COMMUNITY DEVELOPMENT DEPARTMENT
80 Columbia Avenue ♦ Marysville, WA 98270
(360) 363-8100 ♦ (360) 651-5099 FAX

February 4, 2022

Re: Kallcott (Sunnyside Road) PRD – *Pre-Application*
PREA22-002

This letter is intended to summarize the Planning Divisions comments regarding the above referenced proposal. These comments are preliminary in nature and are based on the applicable development standards outlined in the Marysville Municipal Code (MMC). Preliminary comments do not vest an applicant to the existing MMC. Development conditions are based on the most current MMC provisions in effect at the time a *Determination of Completeness* has been issued on a formal land use application.

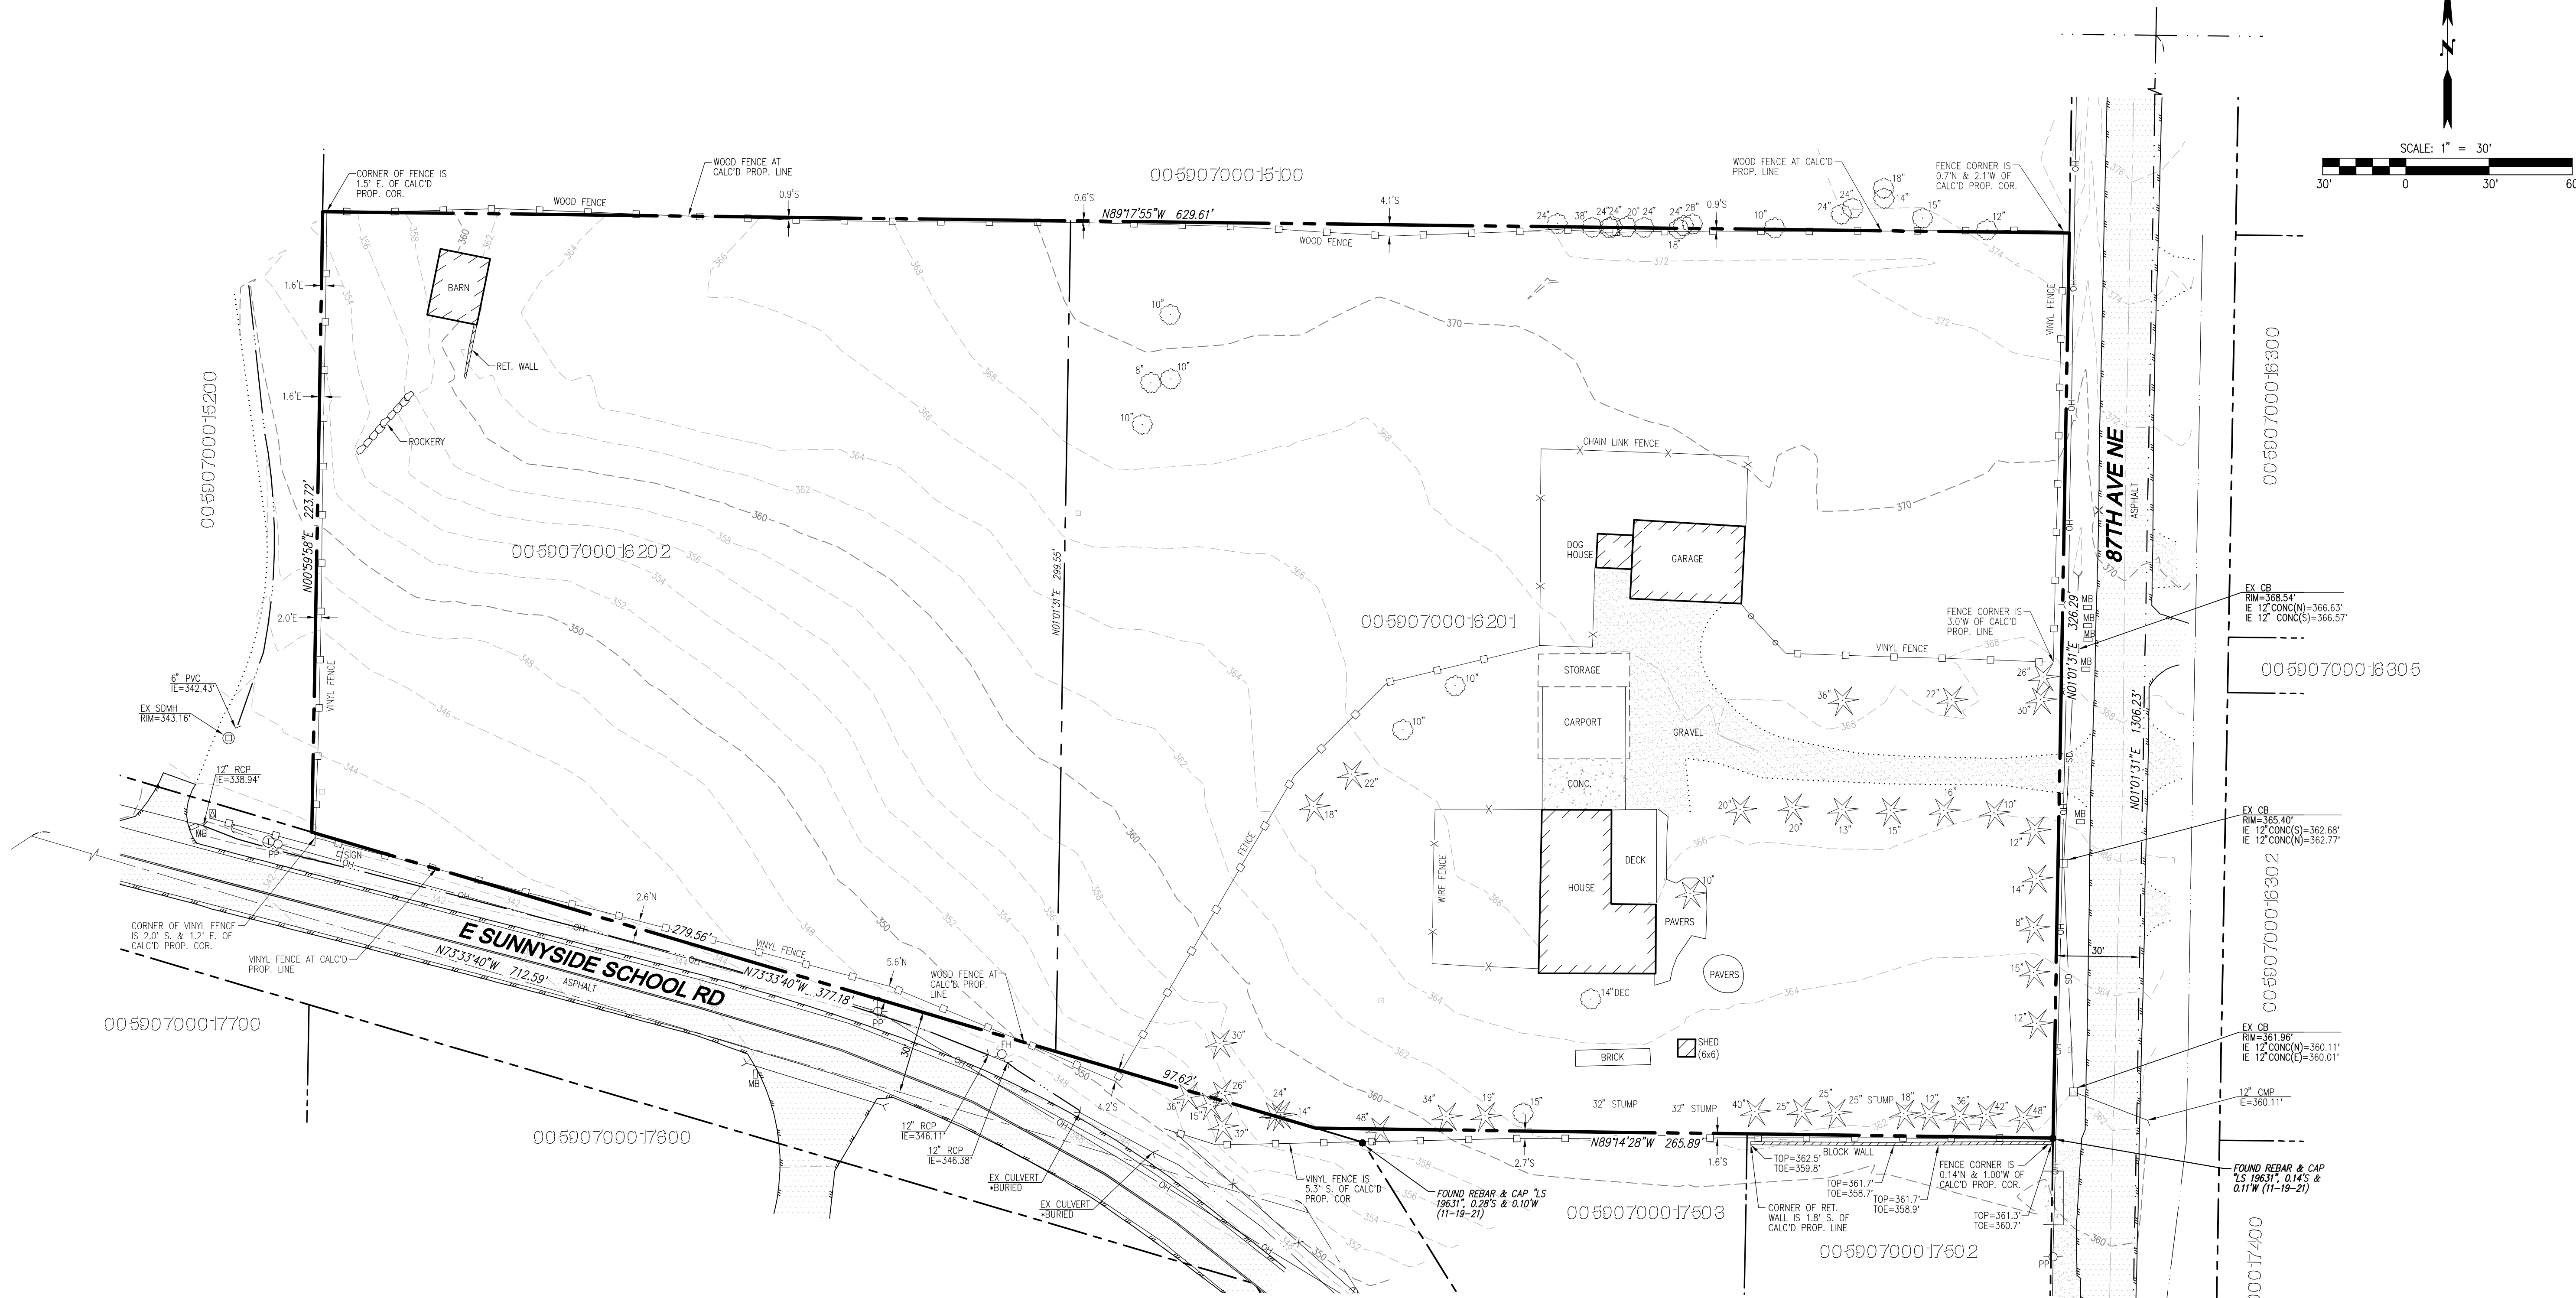
- . Common open space is required pursuant to MMC [22G.080.100](#). The common open space must be arranged to maximize usability.
- Staff comment:** as proposed, staff has concerns regarding access to Tract 998. It appears the tract is cut off from the development and is only accessible via E Sunnyside School Road.

- Staff comment:** based on the information provided, the proposal appears to meet this shared access requirement. Engineering Services and Traffic may have concerns relating to the distance between the intersection of Drive A and Drive B with proposed Tract 997.

Staff Comment: proposed Lots 11 – 15 are required to front onto 87th Avenue NE. Lot 11, fronting on 87th Ave NE and Drive A, will be allowed to have a side-yard orientation towards the arterial, with vehicle access off Drive A.
